Pre-Design Investigation
(Additions)

ADDRESS 2425 Monroe NE ZONE ATLAS # H-17

PROPOSED DEVELOPMENT Addition

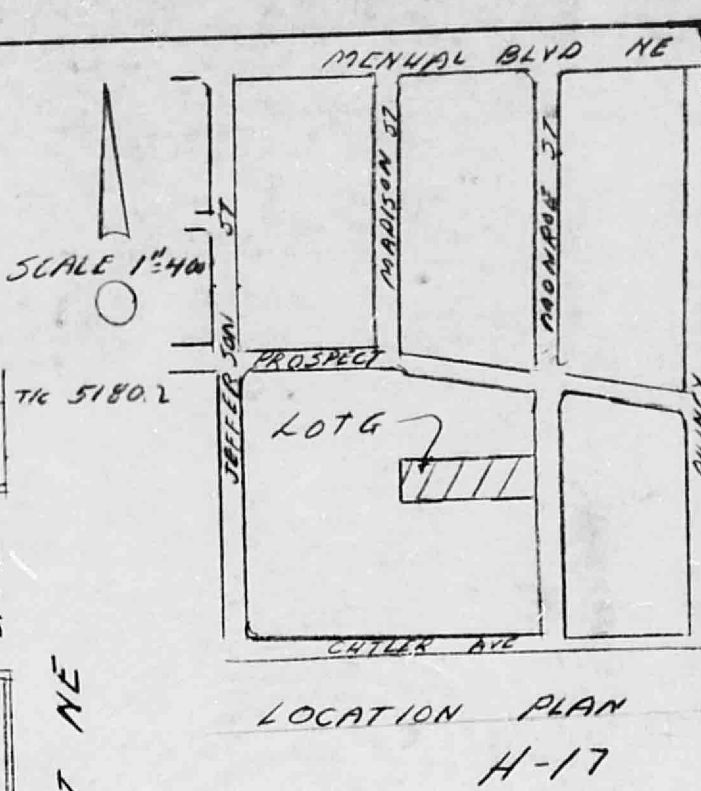
All of the existing drainage is being routed to the rear of the lot
Need more information pertaining to existing and proposed elevations.
More computations needed as far as total area being drained
to proposed ponds. Existing retaining wall to the North, may need
a retaining wall to the South.
